**KIRKLEES METROPOLITAN COUNCIL
INVESTMENT & REGENERATION SERVICE**

DELEGATED DECISION TO DETERMINE PLANNING APPLICATIONS

Reference No: 2017/62/93316/E
Site Address: 5, Harewood Grove, Heckmondwike, WF16 0DD
Description: Erection of two storey side and rear extension
Recommending Officer: Olivia Roberts

Officer Report

DRG:
PROPOSED FLOOR PLANS & ELEVATIONS

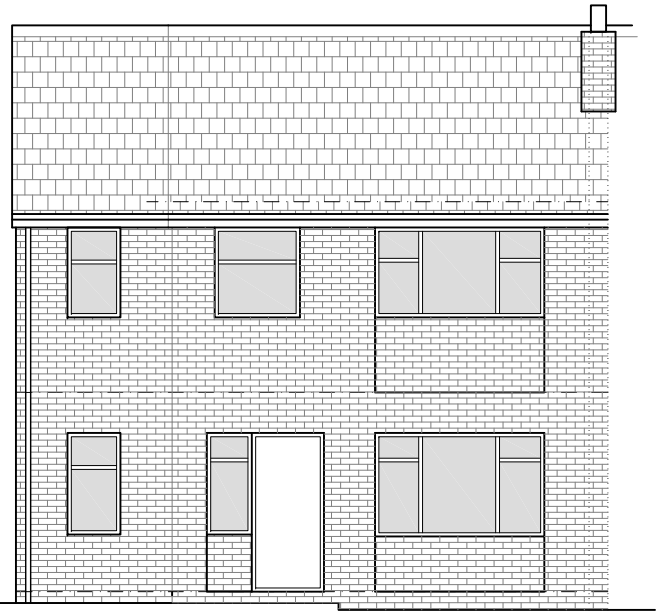
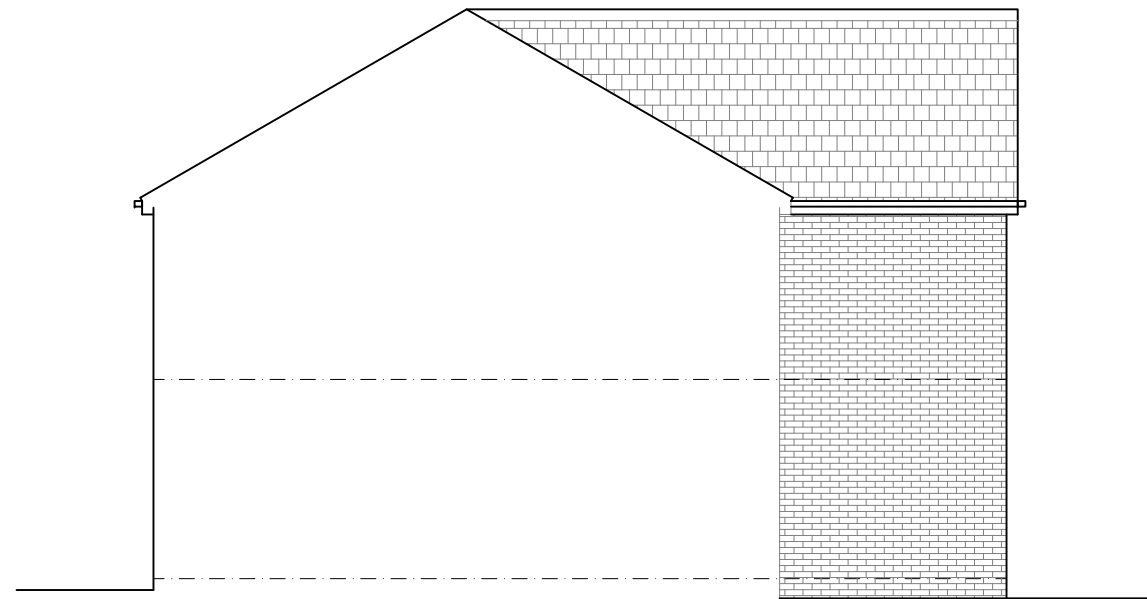
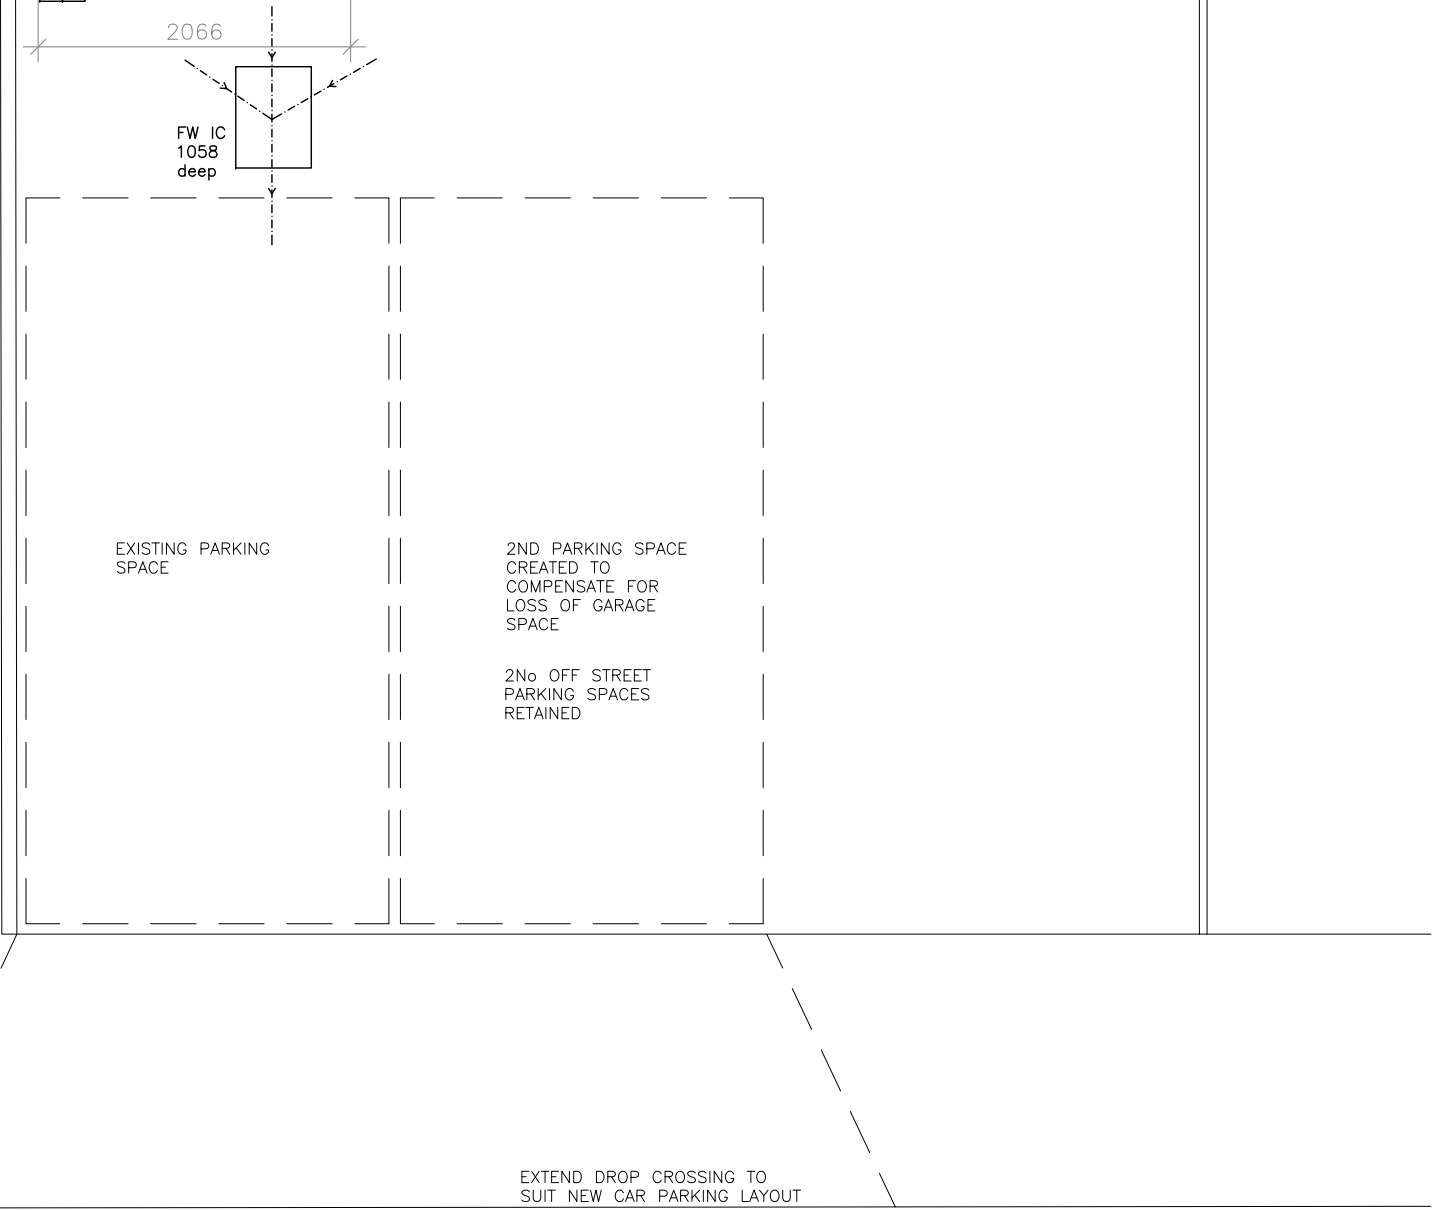
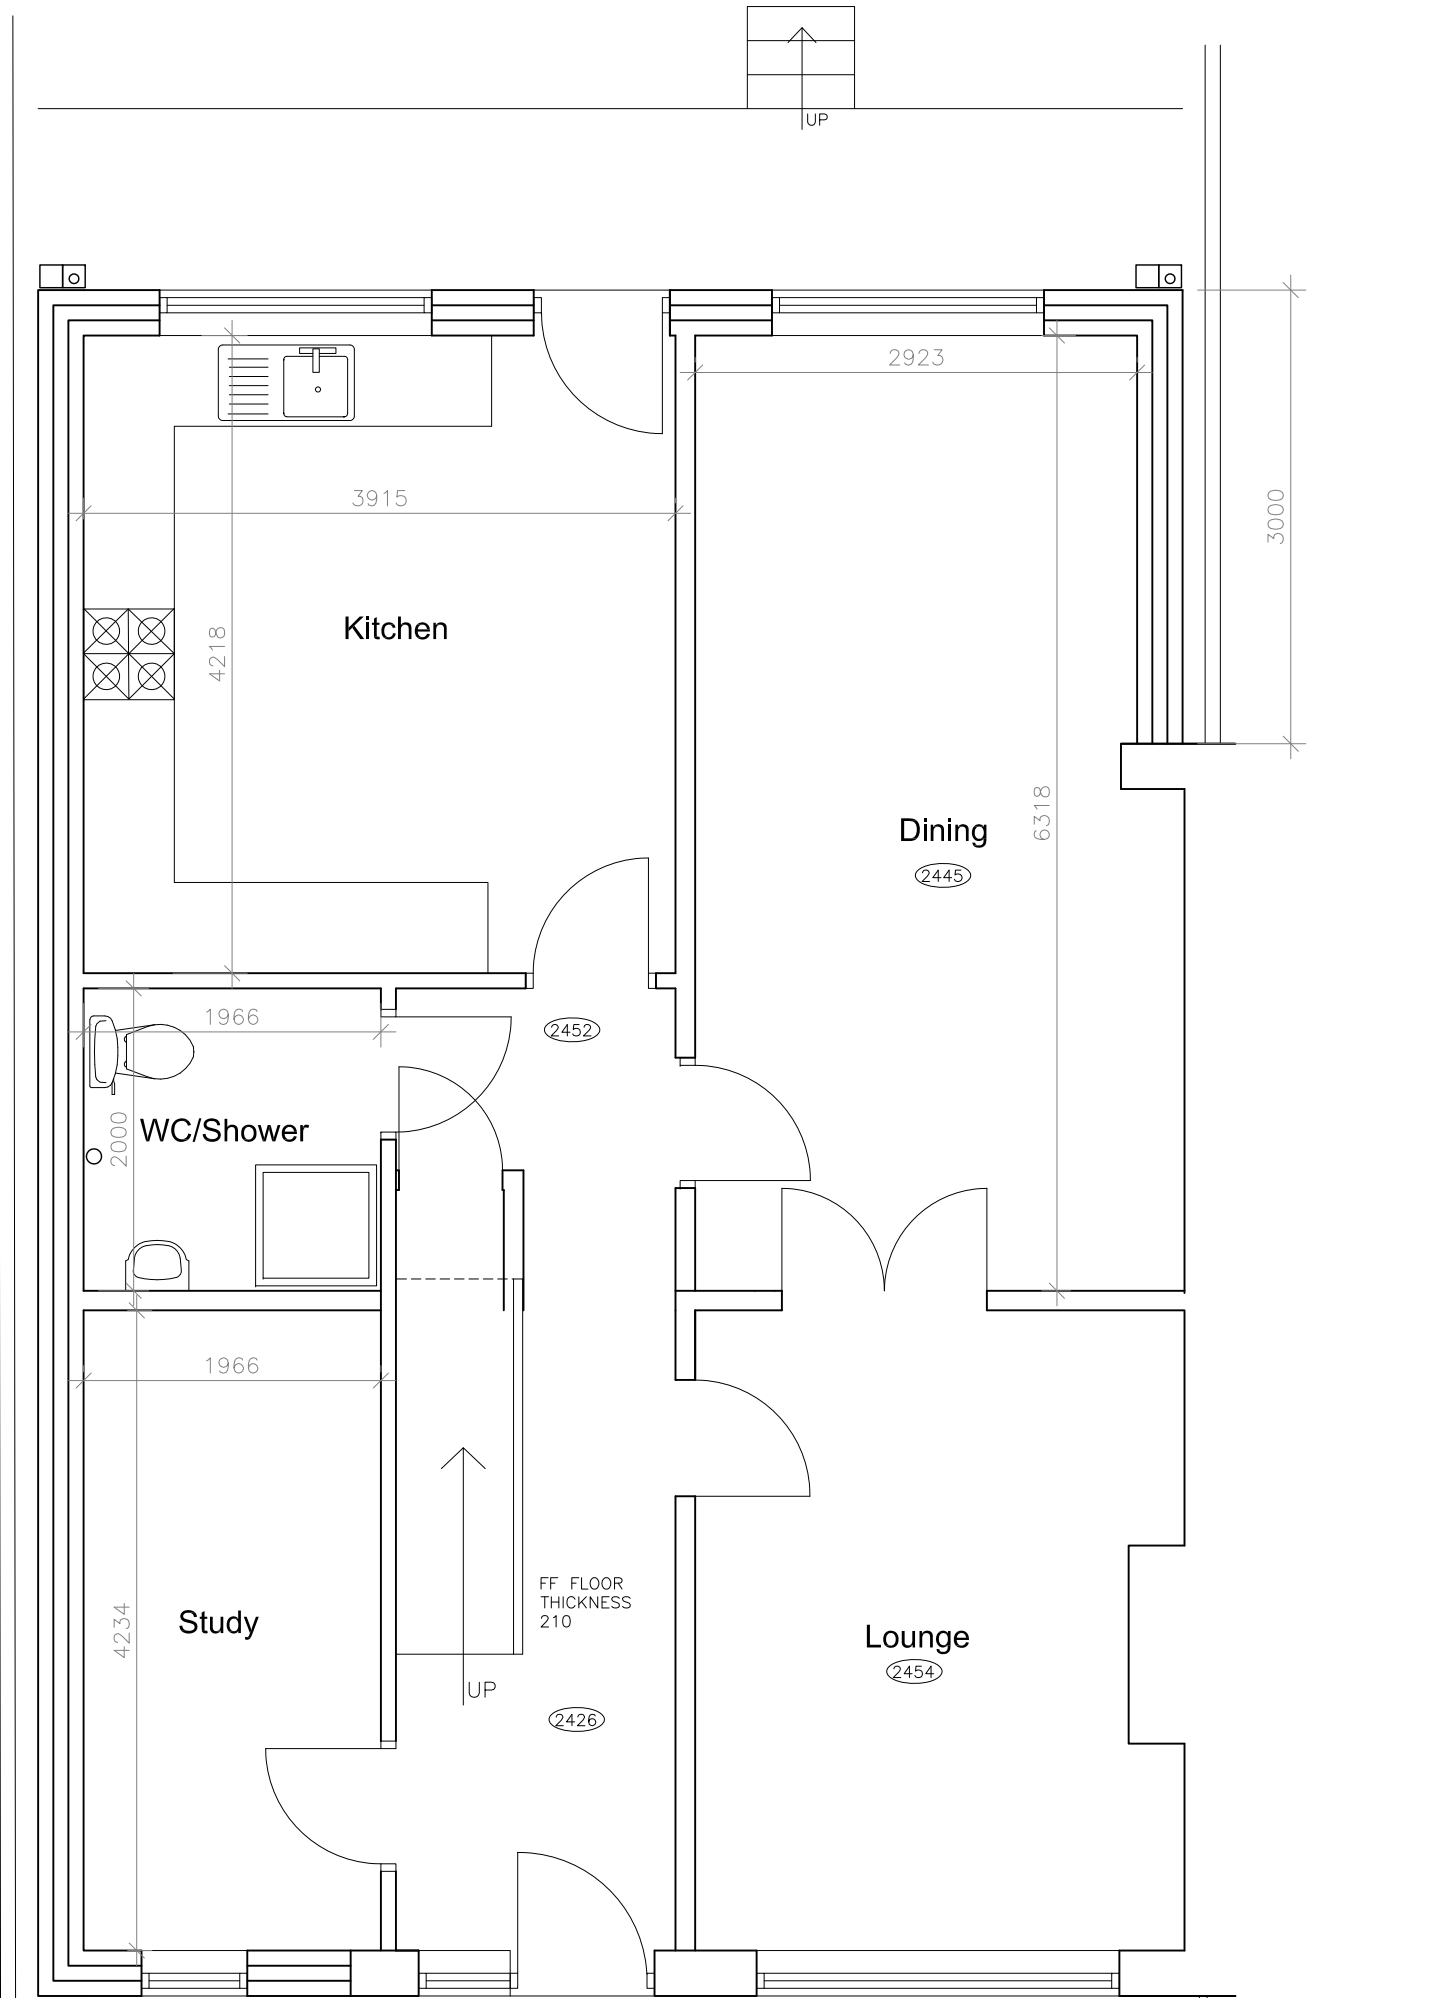
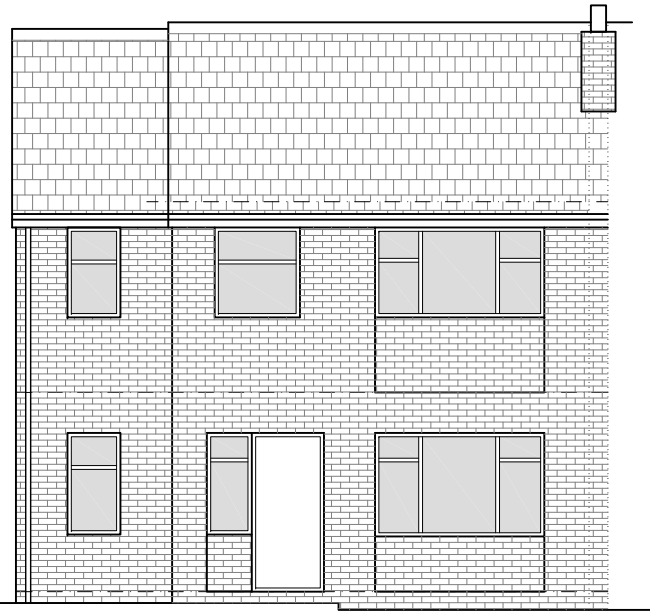
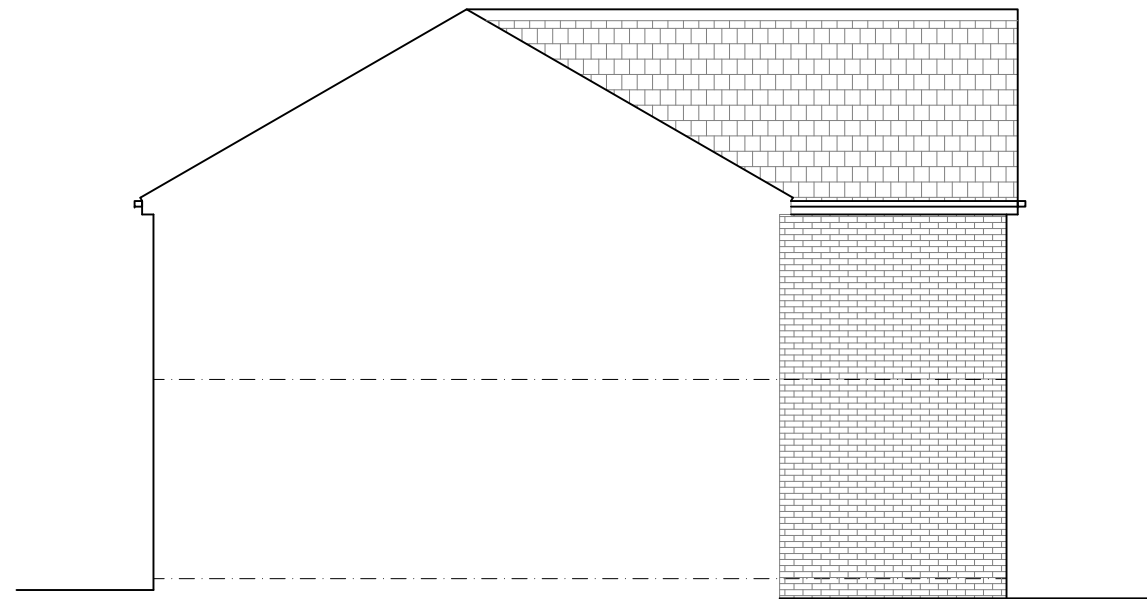
On the original plans, the front elevation of the proposed side extension sat flush with the front elevation of the host dwelling. Furthermore, the ridge height of the proposed extension matched that of the original dwelling. As the application site is a semi-detached property it was likely that the development could result in an undesirable terracing effect should the neighbouring property erect a similar extension. Amendments were sought to decrease the ridge height and set the front of the side extension in from the front elevation of the host dwelling to comply with policy BE14 of the UDP. The ridge height of the proposed extension has been set down from that of the host dwelling and the front of the extension has been set back from the front elevation of the host dwelling by 0.30 metres.

The case officer sought amendments to set the front of the side extension back from the front elevation of the host dwelling and to reduce the ridge height to comply with policy BE14 and to reduce the extent to which the development would result in an undesirable terracing effect.

Although the proposed two storey extension will be located to the side of the semi-detached property, an undesirable terracing effect will not be created due to the front of the extension being set back from the front elevation of the original dwelling. Furthermore, the ridge height of the proposed extension will be lower than that of the host dwelling. In addition, the application site is set forward slightly of the neighbouring property, no. 3 Harewood Grove which will further prevent an undesirable terracing effect. The proposal will therefore comply with policy BE14 of the UDP.
